City of Albuquerque Stormwater Construction Site Inspection Report

General Information					
ESC File No.	K09E048B	Project Name:	Dutch Brothers		
NPDES Id. No.	NMRI005FQ	Location:	210 98th St NW		
9/14/2023	Owner		Contractor		
Operator	Heritage Trails Development, LLC				
Contact name & title	John Caglia		Joseph Green		
e-mail	john.caglia@dutchbros.com		jgcsdevelopment@gmail.com		
Contact Phone #	714-883-9092		469-888-3285		
COA Inspector	Chancellor English		Start/End Time:	1030am	
Construction Phase:	infrastructure nearly complete				
Type of Inspection:	<input type="checkbox"/> Regular	<input type="checkbox"/> Storm Event	<input type="checkbox"/> Post Storm Event >0.25"	<input type="checkbox"/> 311/Complaint	<input checked="" type="checkbox"/> Follow Up
Weather at time of inspection?	Clear		Temperature: ~	80	
Estimated date of last storm 0.25" or greater	9/13/2023

Job Number: 22187
Sheet: C13
2019 DB
Franchising USA, LLC

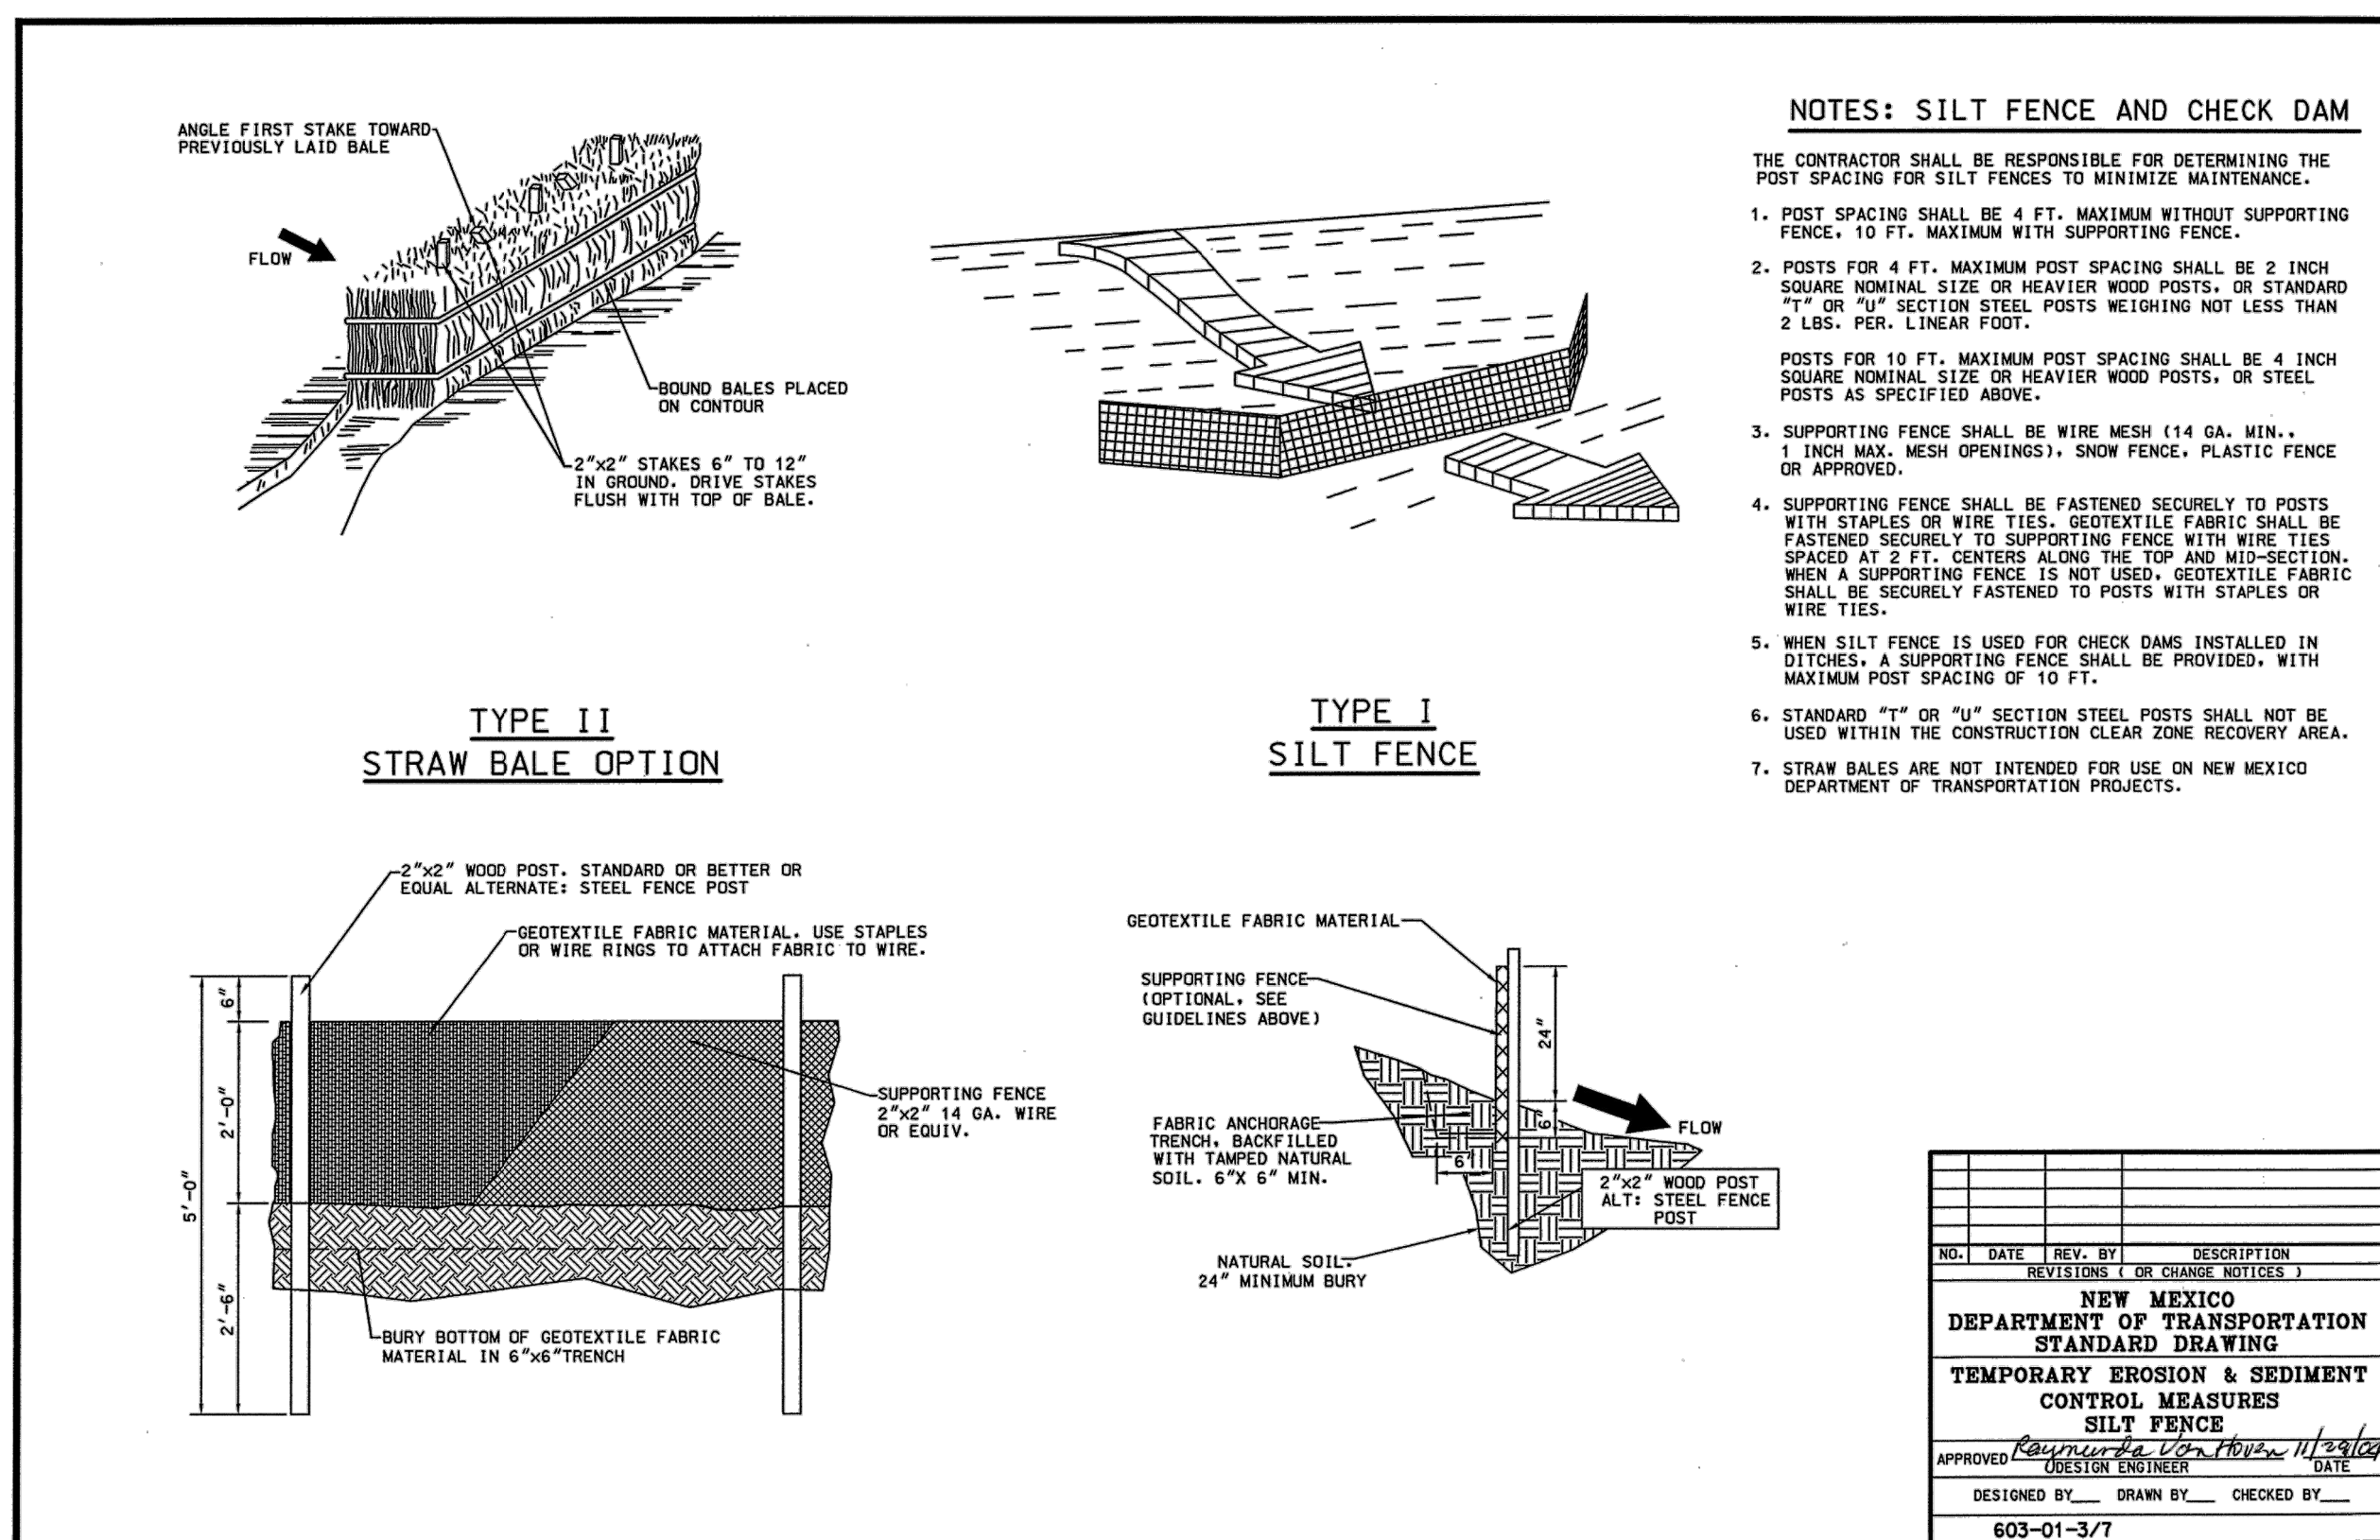
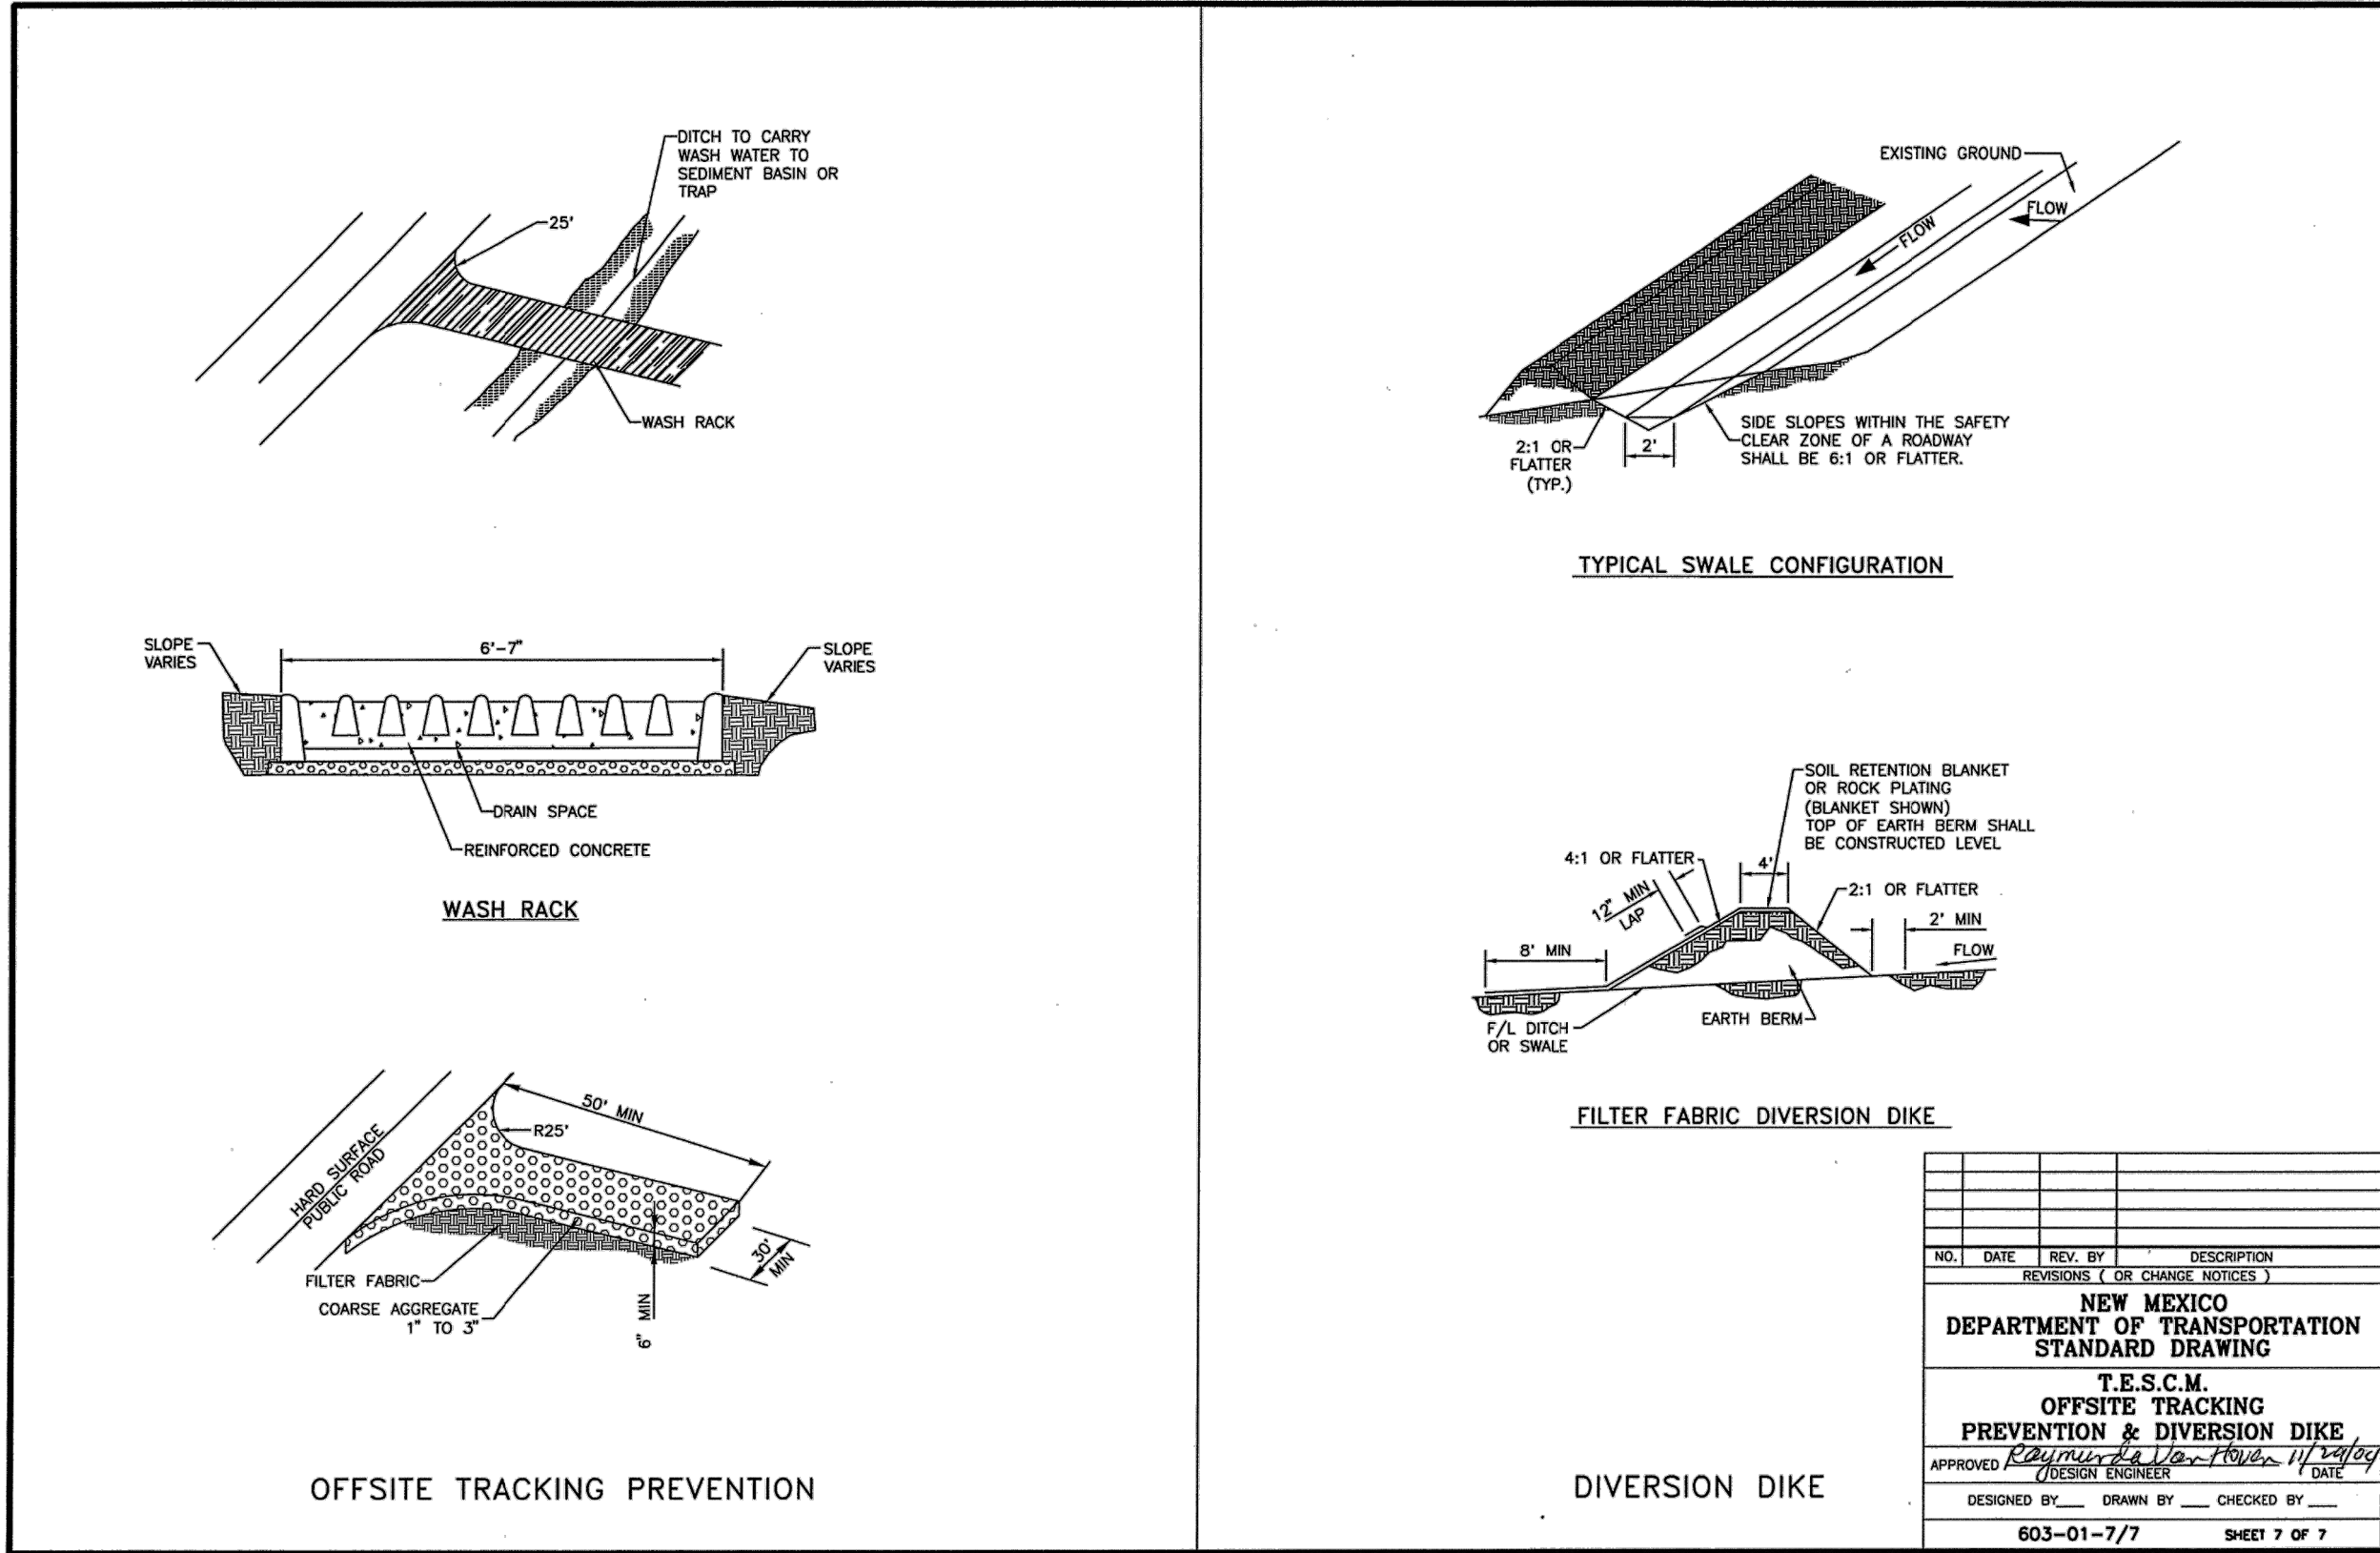
3	There are multiple gaps in the perimeter silt fence in violation of CGP Parts 2.1.2 and 2.1.4. Subcontractors are not using the designated construction exit and instead using a low point of the site for access in violation of CGP Part 2.2.4. Required mitigation: CGP Part 2.1.2 requires you to design and install all stormwater controls in accordance with good engineering practices, including all design specifications. You must install sediment controls along any perimeter areas of the site that are downslope from any exposed soil or other disturbed areas per CGP Part 2.2.3. To minimize track-out, you must restrict vehicle use to properly designated exit points and use appropriate stabilization techniques at all points that exit onto paved roads, according to CGP Part 2.2.4.				
4	There were spots of concrete washout on the ground and the site is missing a designated washout container in violation of CGP Part 2.3.4. Required mitigation: CGP Part 2.3.4 requires you to direct wash water into a leak-proof container or leak-proof and lined pit and to not allow liquid wastes to be disposed of through infiltration or to otherwise be disposed of on the ground.
